**RE: Restaurant Depot
1901 Menaul Blvd NE
Grading and Drainage Plan
Engineer's Stamp Date: 06/28/22
Hydrology File: H15D039**

Based upon the information provided in your submittal received 07/11/2022, the Grading & Drainage Plan **is not** approved for Building Permit and Grading Permit. The following comments need to be addressed for approval of the above referenced project:

C4.0

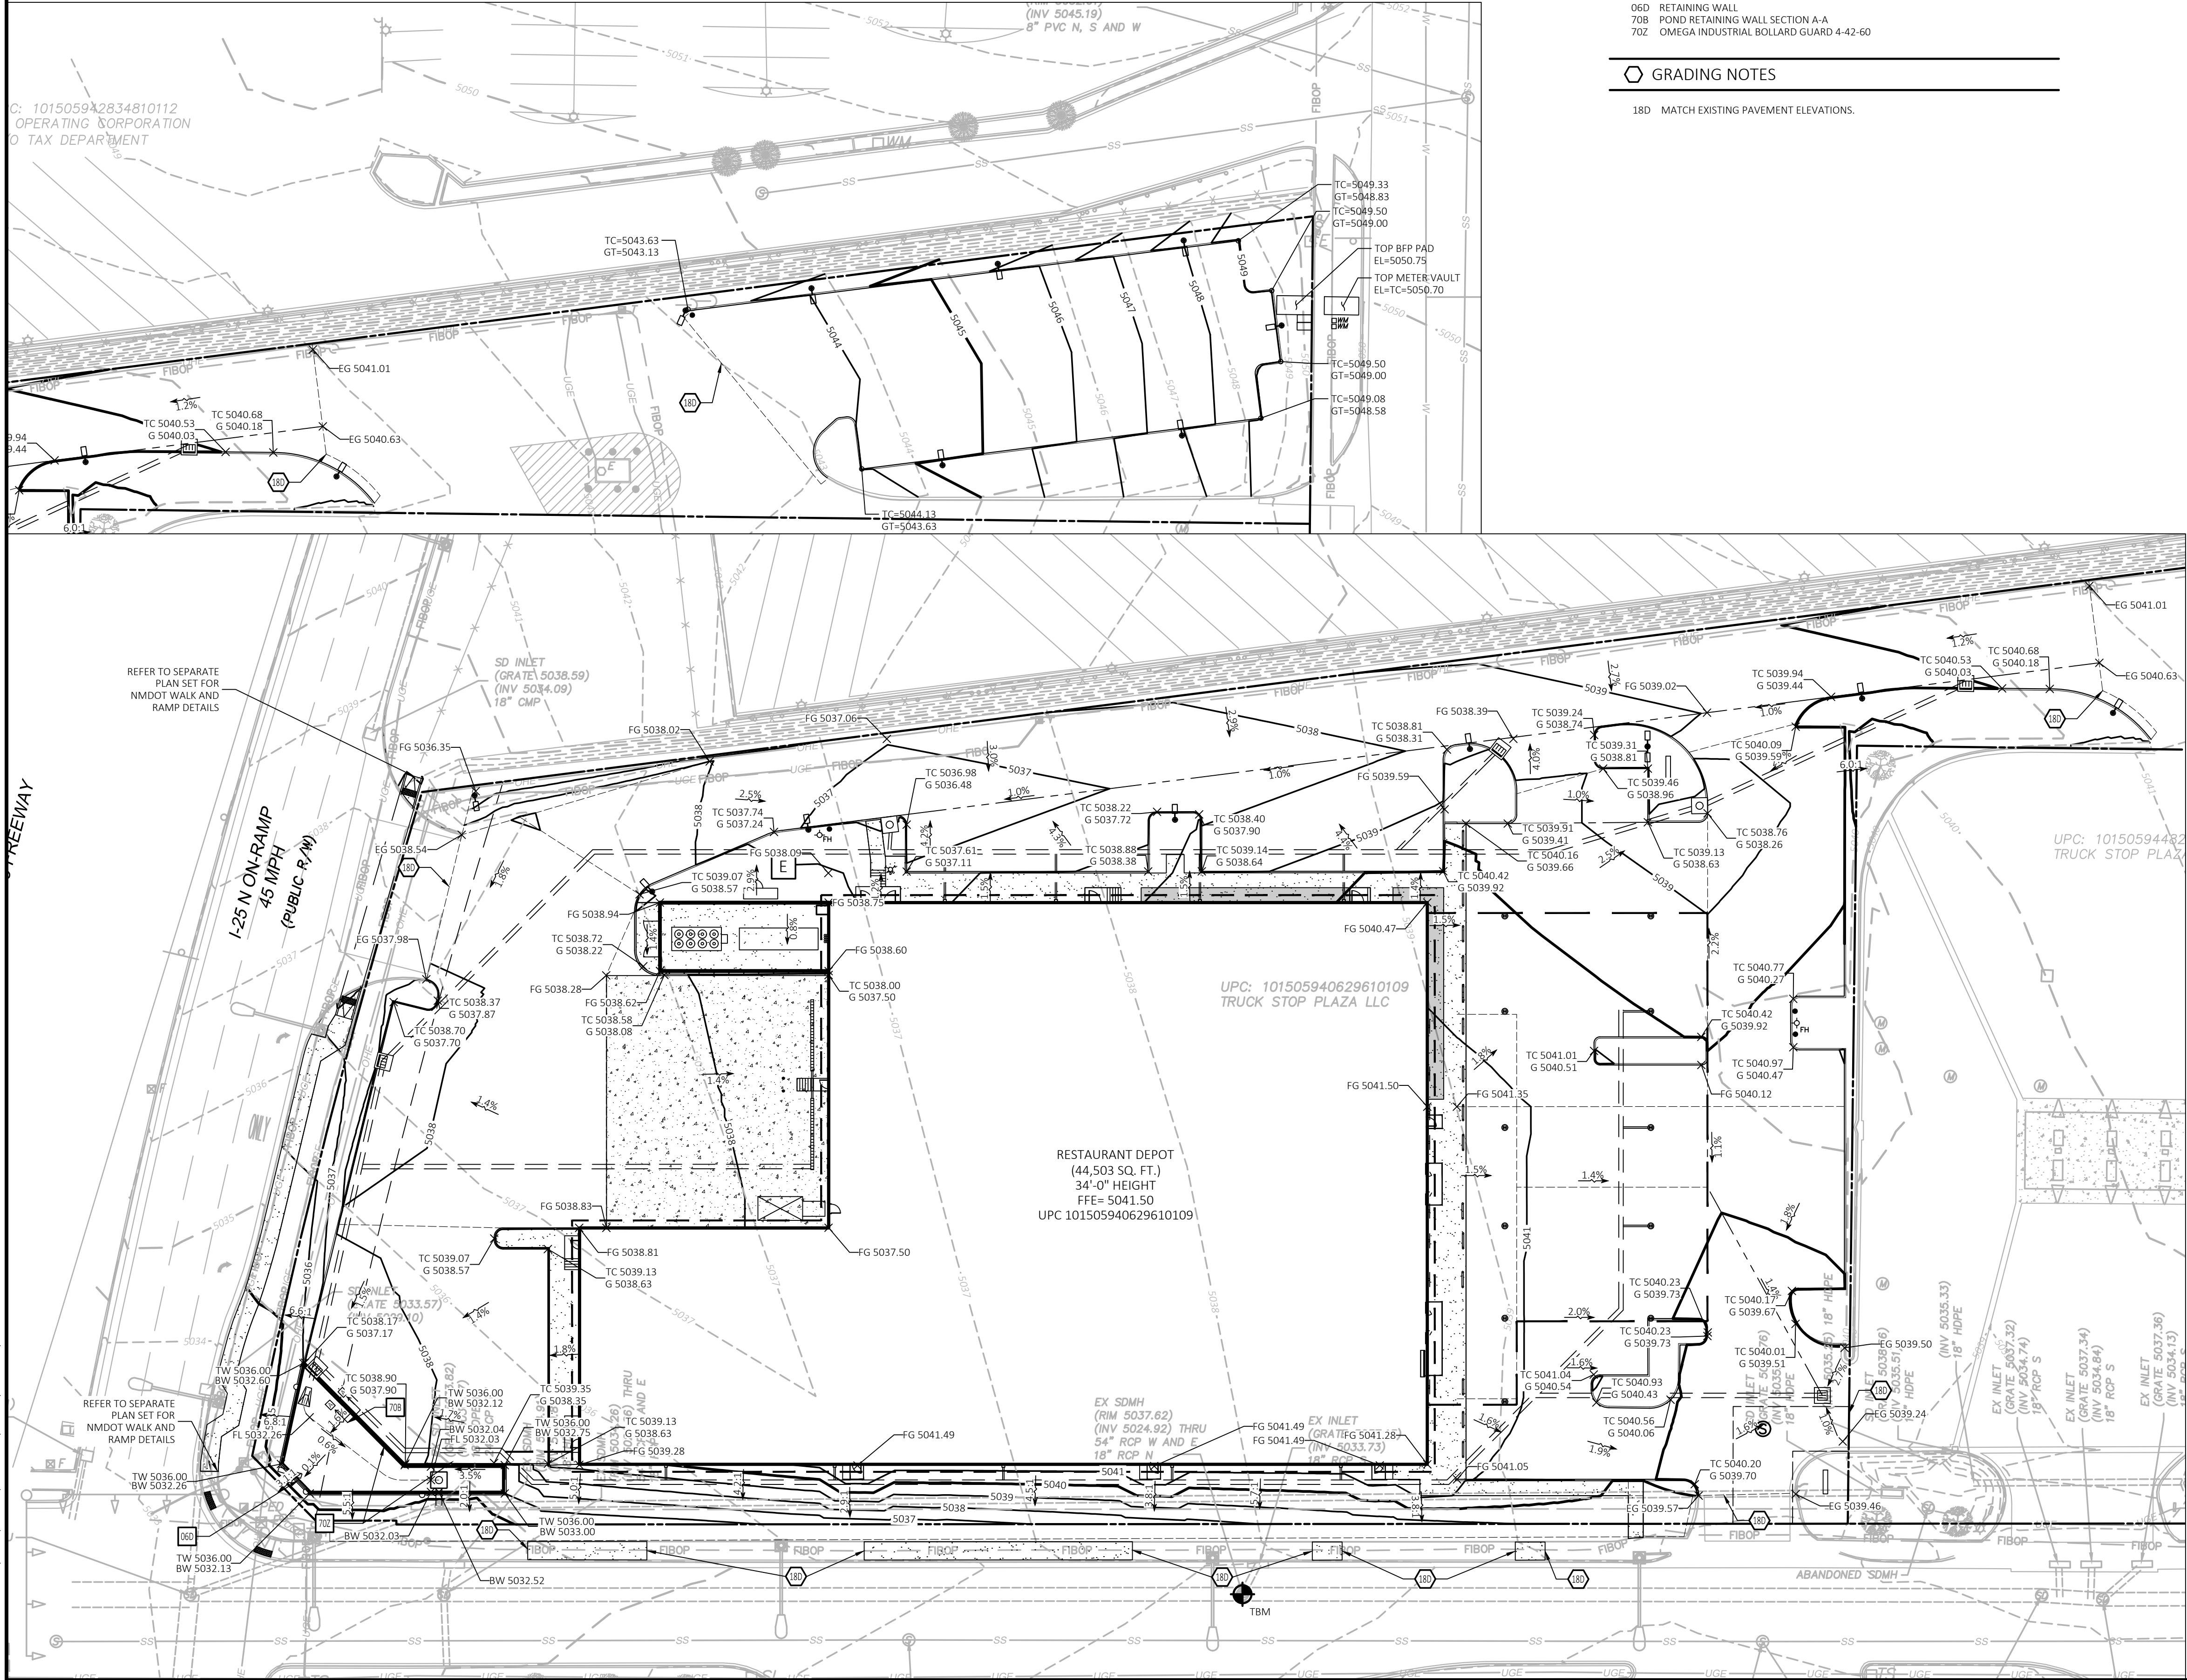
Grading Plan - C4.0

1. Per the DPM, the following must be on the Grading Plan.
 - a. Please provide a Vicinity Map. Typically, this is the Zone Atlas. This can be downloaded in pdf format from the City of Albuquerque's website.
 - b. Please provide the Benchmark information (location, description and elevation) for the survey contour information provided.
 - c. Please provide the FIRM Map and flood plain note with effective date.
 - d. Please provide a legal Description of the property.

C4.1

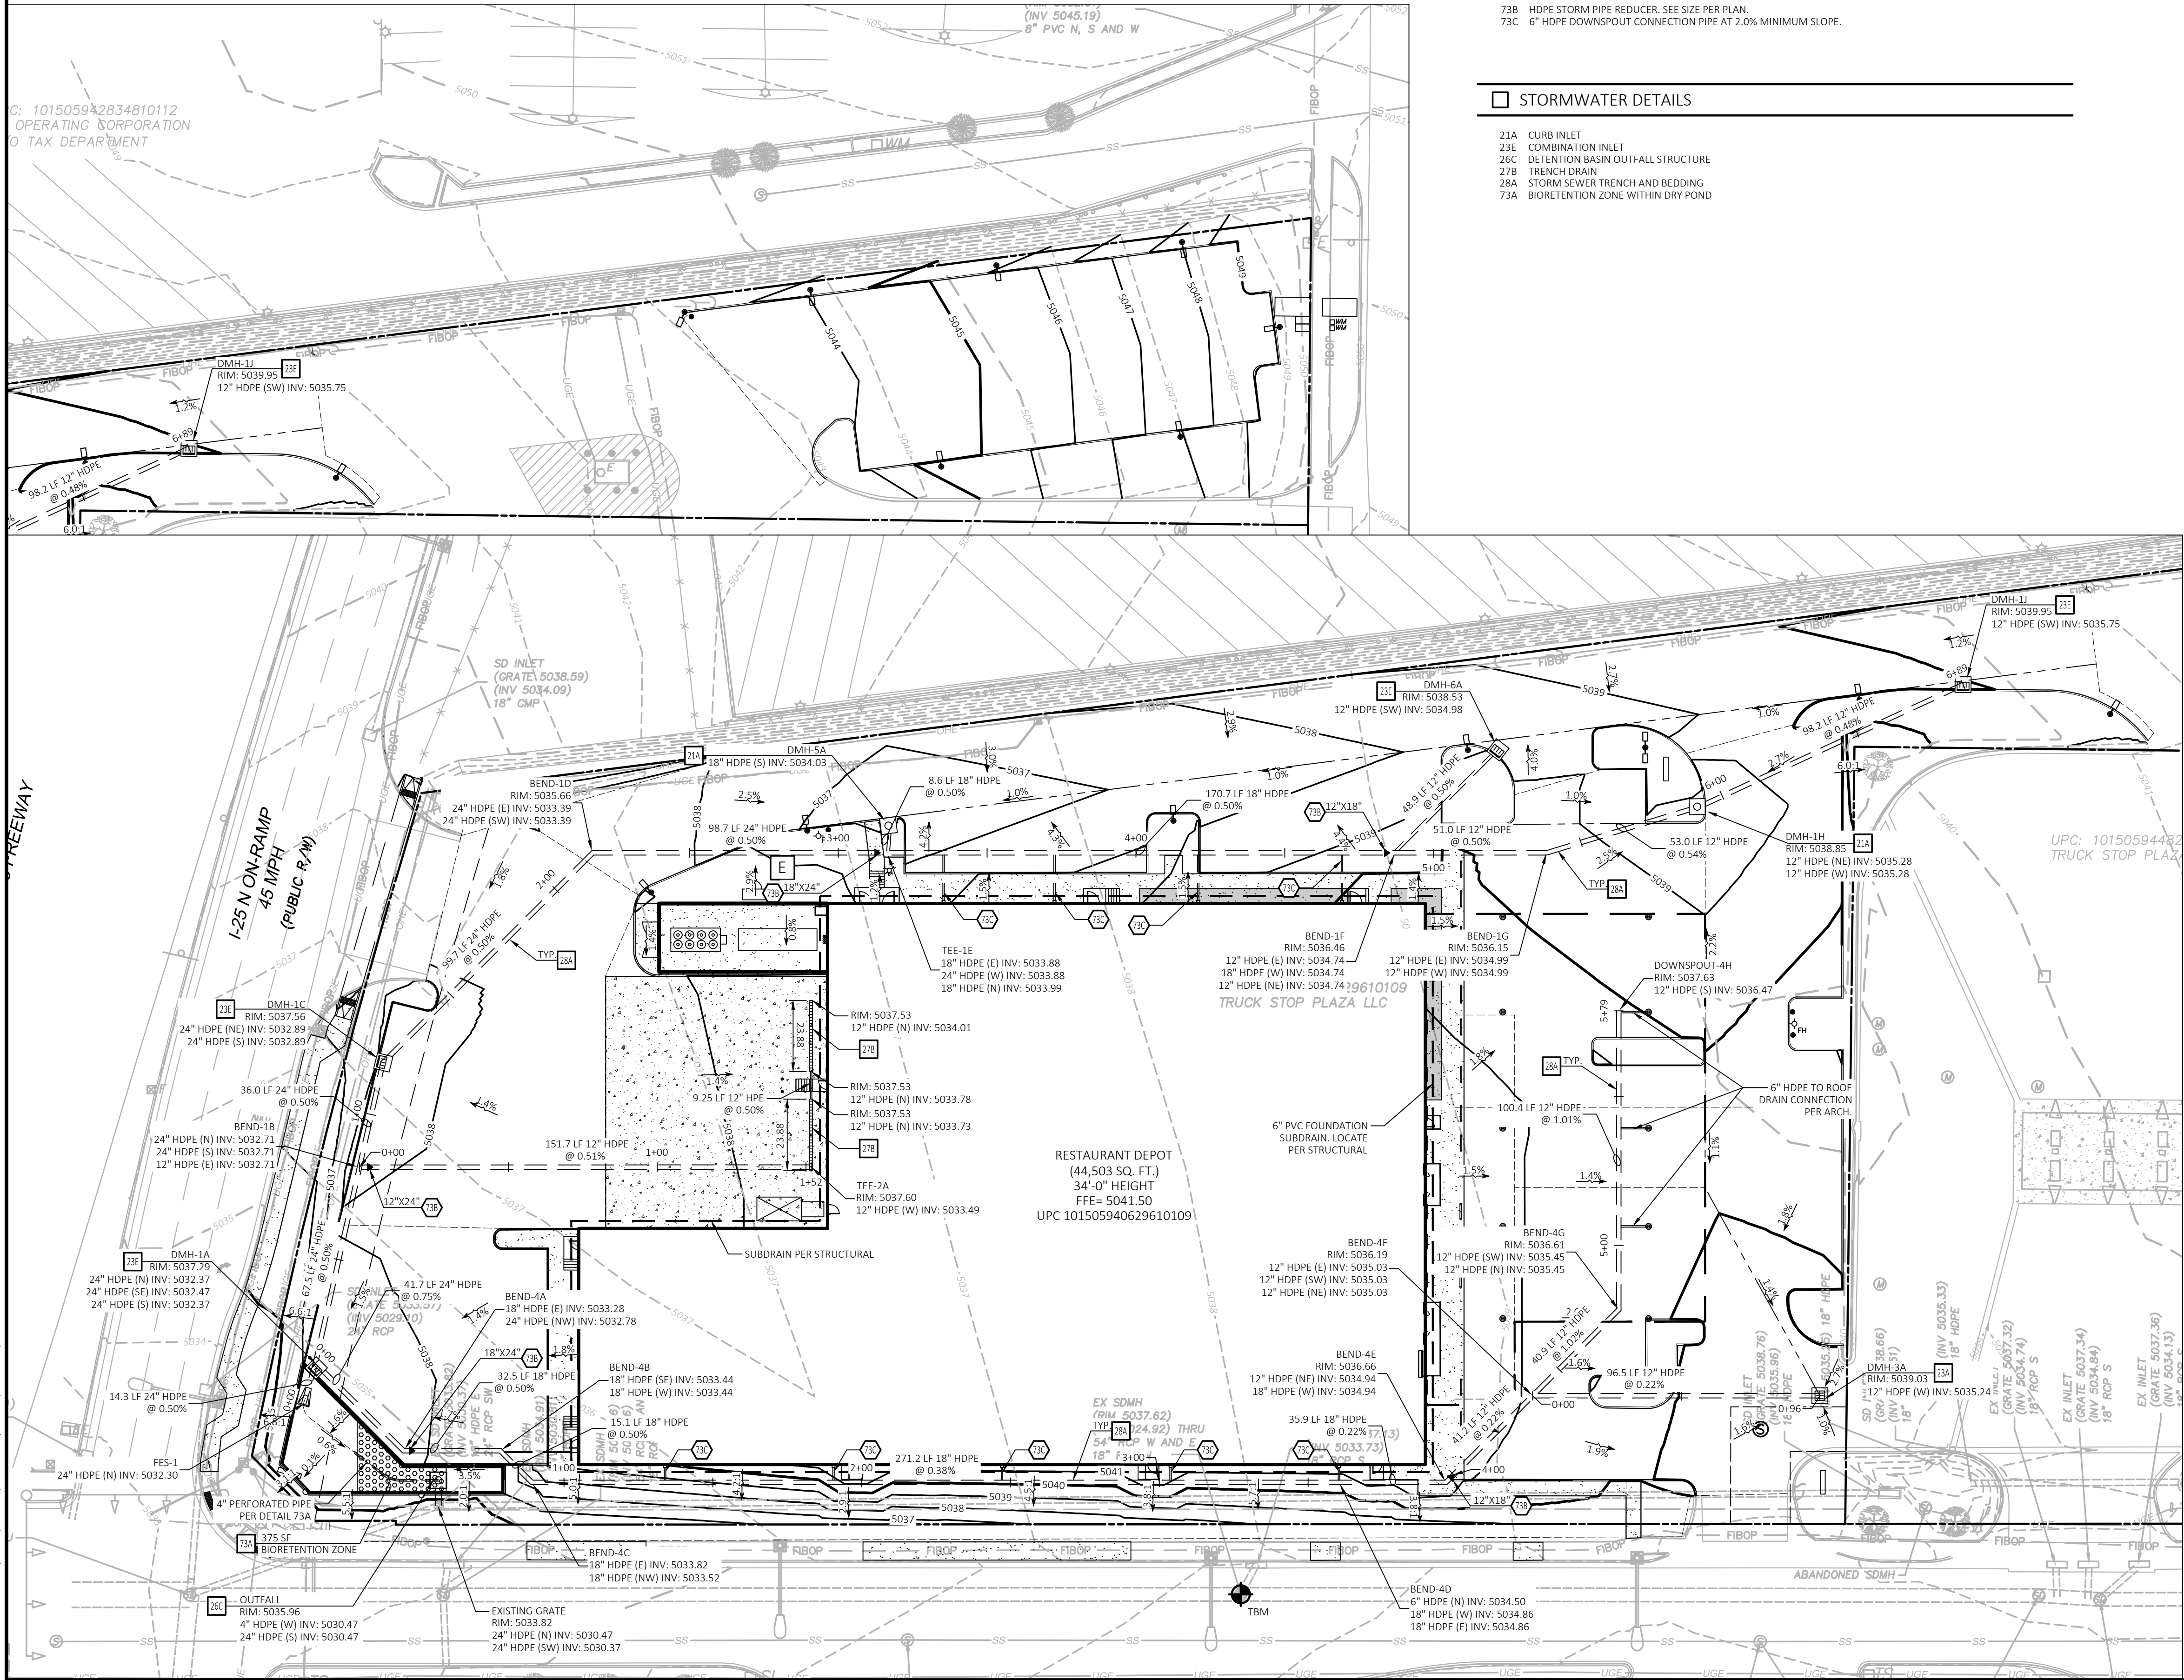
Drainage Plan – C4.1

2. Please use the procedure for 40 acre and smaller basins as outlined in Development Process Manual (DPM) Article 6-2(a). Please provide both the existing conditions and proposed conditions for the 100 year-6 hour storm event.
3. Provide management onsite for the Stormwater Quality Volume (SWQV) in accordance with the Drainage Ordinance, § 14-5-2-6 (H) and the DPM Article 6-12 Stormwater Quality and Low-Impact Development for the sizing calculations. To calculate the required SWQV, multiply the impervious area draining to the SWQ pond by 0.42 inches for new development sites and 0.26 inches for redevelopment sites. This development is a

re-development so please use 0.26 in this site's calculations. Please show both the required and the provided volume.

4. The onsite drainage should be directed to the stormwater quality (SWQ) ponds prior to being collected in a private underground drainage system. These SWQ ponds need to be sized for the areas draining to them. Also, please show the top and bottom of the ponds along with the volume for each pond.
